CITY OF ALBUQUERQUE

Re: Amestoy Drywall Office Drainage Report
Engineer's Stamp dated 11-5-04 (B13/D1A)

Re: Drainage Report for Amestoy Drywall Office, ZAP B-13
Engineer's Stamp Dated August 18, 2004

#### AMESTOY DRYWALL OFFICE GRADING AND DRAINAGE PLAN

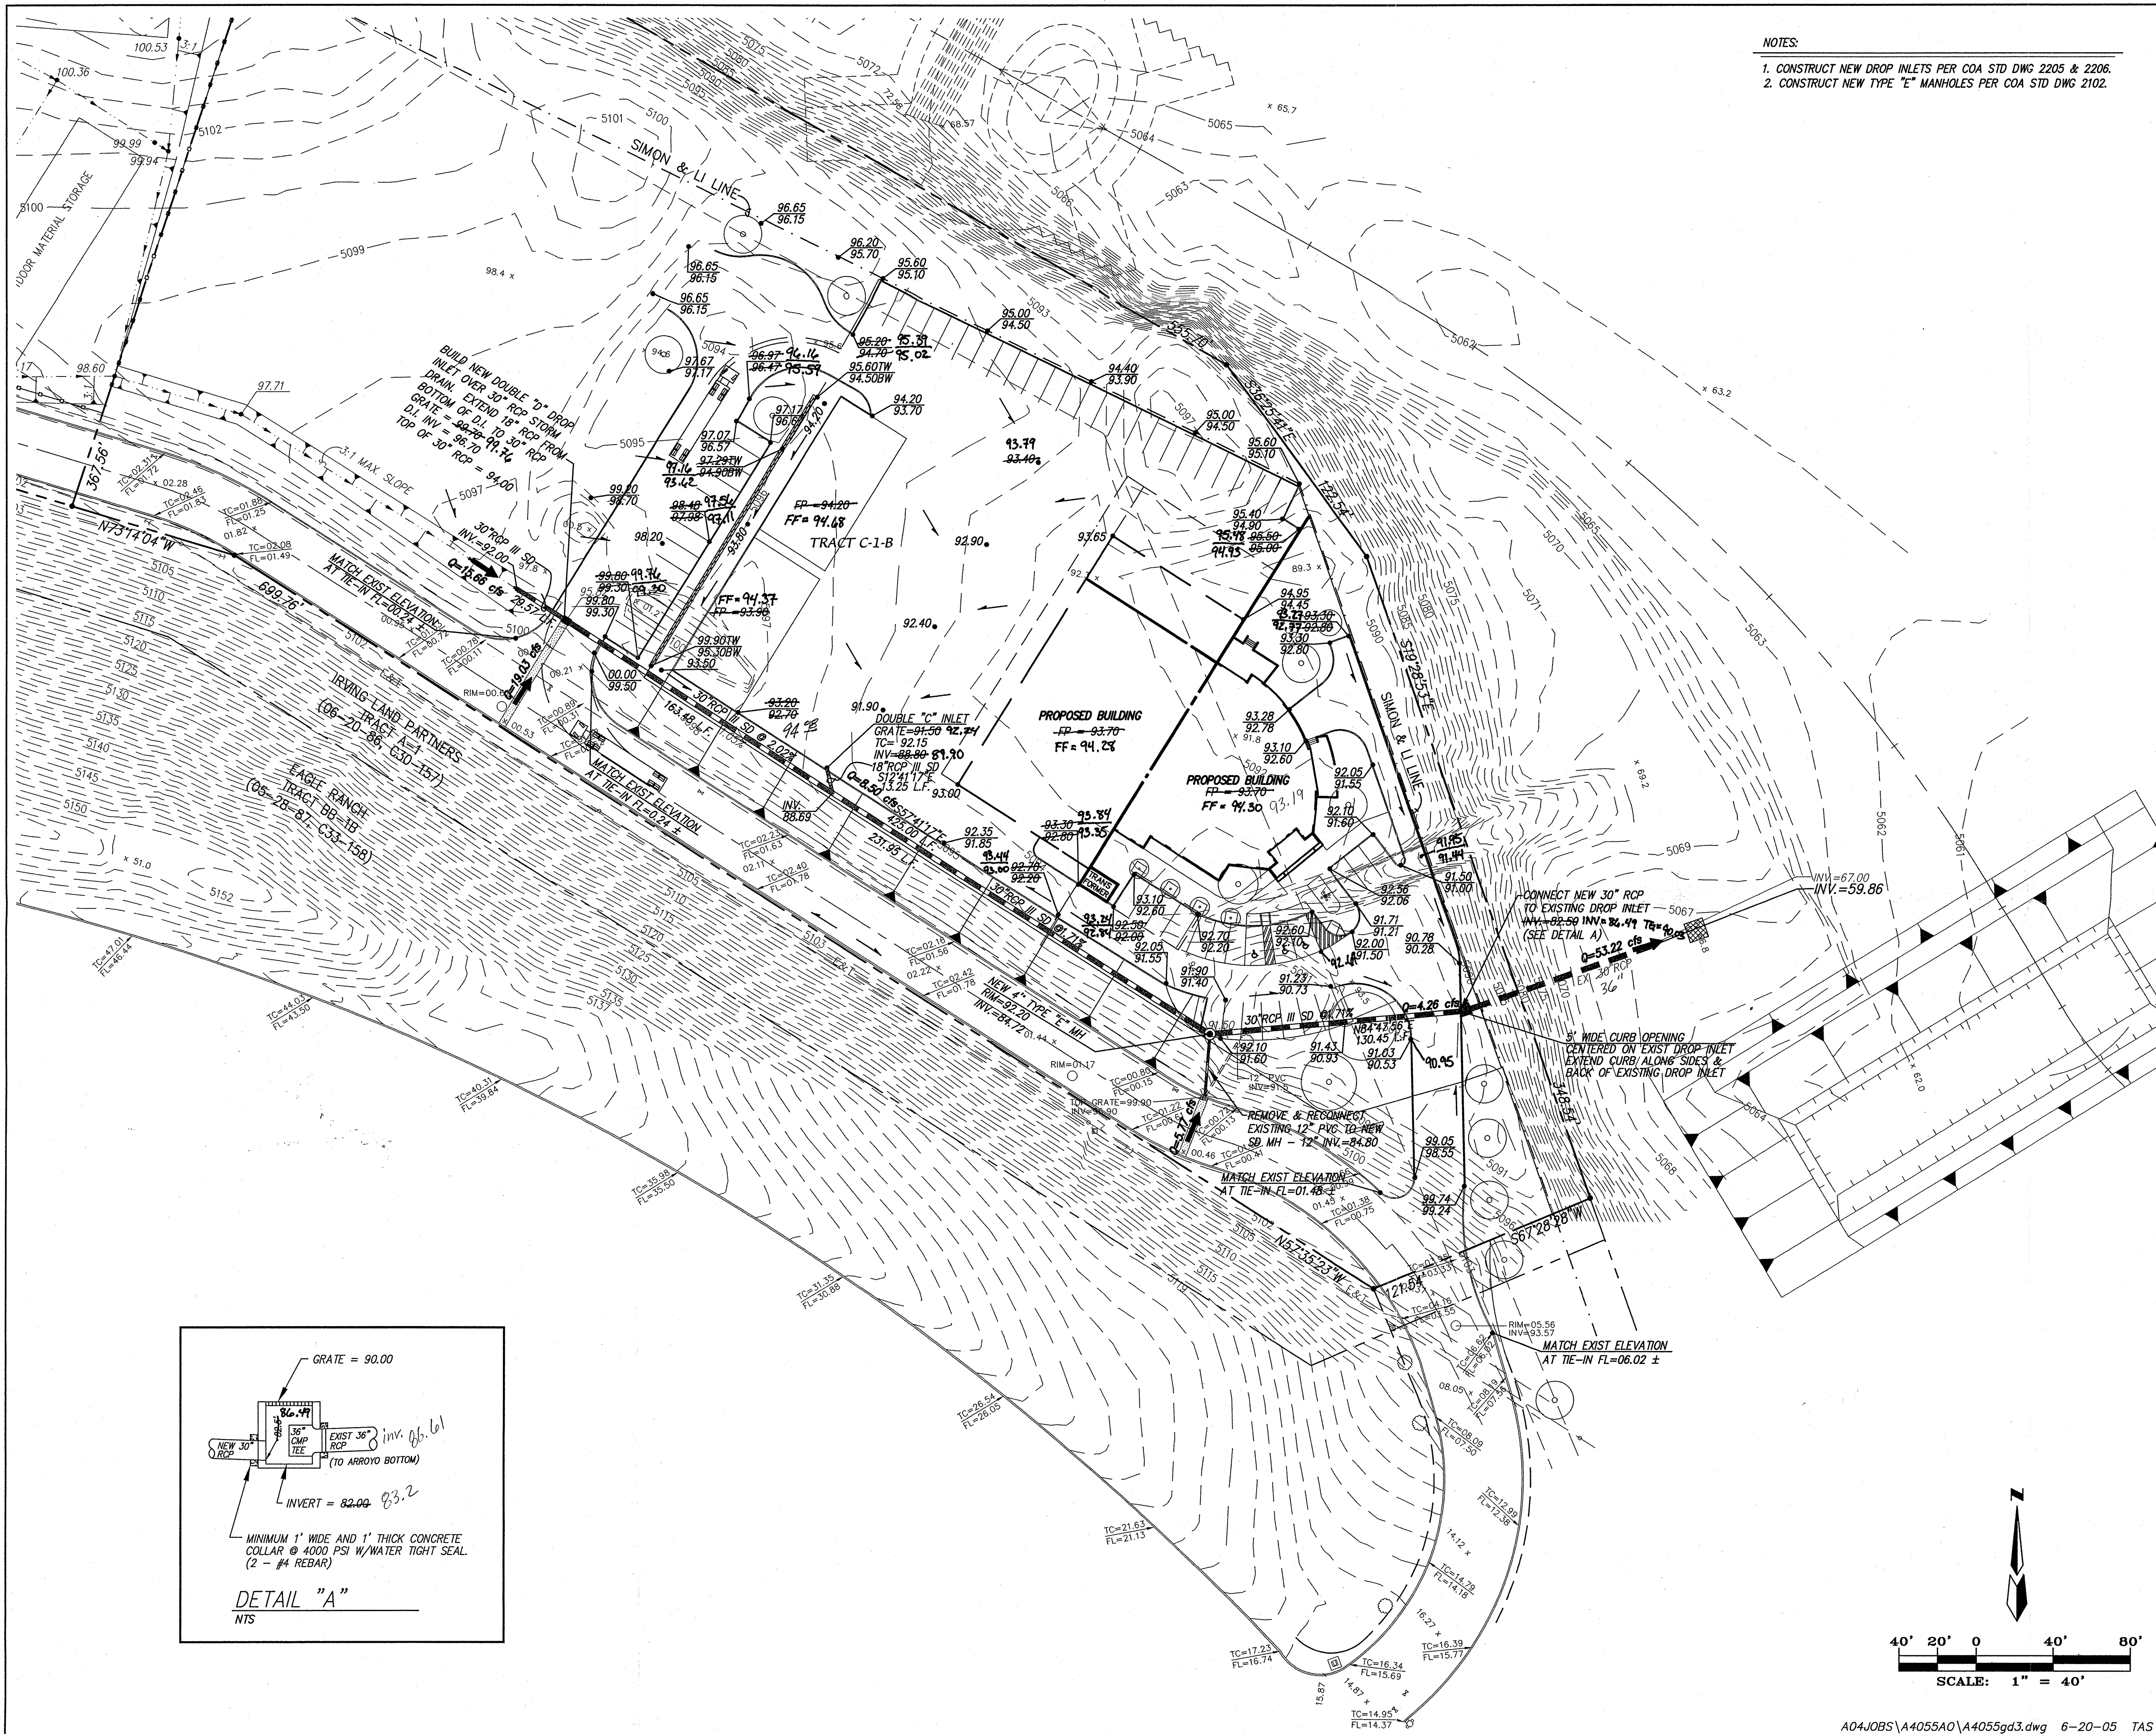
AMAFCA has reviewed the referenced grading plan and the letter from Brad Bingham dated September 17. Minor grading within the prudent line will be allowed. The grading will not adversely affect the integrity of the Calabacillas Arroyo slope since the slope has been stabilized with riprap. Please add a note to the plans that the disturbed slope area will be reseeded.
